**Address: 12 Connaught Street, London, W2 2AF,**

**Proposal: Installation of awning with logos; painting of external shopfront (12 Connaught Street & 1 Porchester Place) coloured in Forest Green; and painted fascia sign.**

Thank you for your application received on 18 October 2023. I am writing to inform you that your application is incomplete for the following reason(s):

LA MARITXU 12 CONNAUGHT STREET	
AUTHOR: LUCIA LARRAGOITI FISHER (ARB ARCHITECT)	
12CS-LL-V0-DR-A-00100	EXISTING ELEVATIONS
SCALE 1:100	
0m 1m 2m 3m

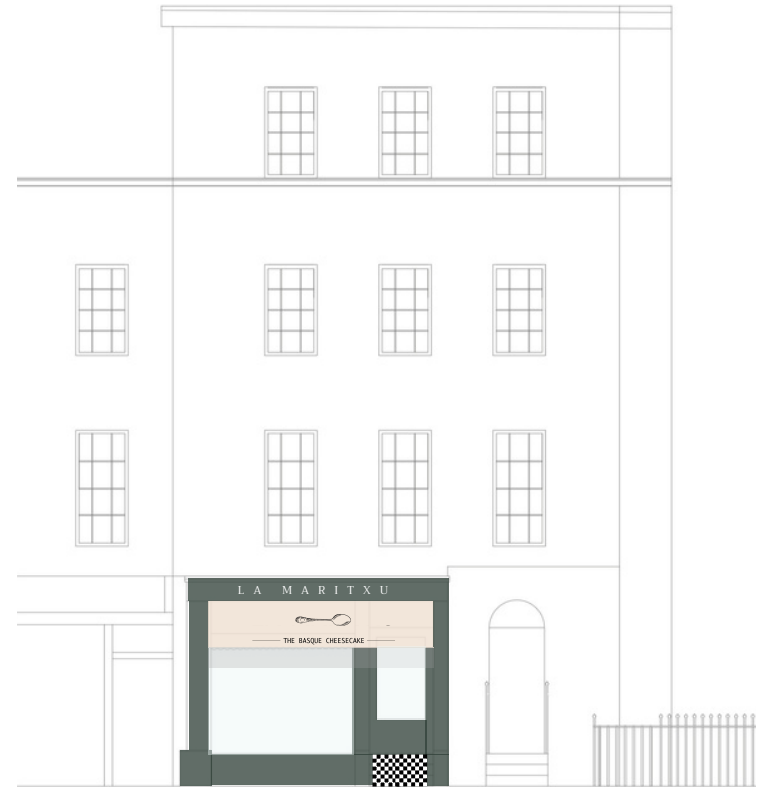
2 The drawings you have provided did not include scale bars and are not labelled as either existing or proposed. Please provide the following:  
- Existing and proposed elevations to include scale bars, correct labelling, and you must give each plan a distinctive reference number.
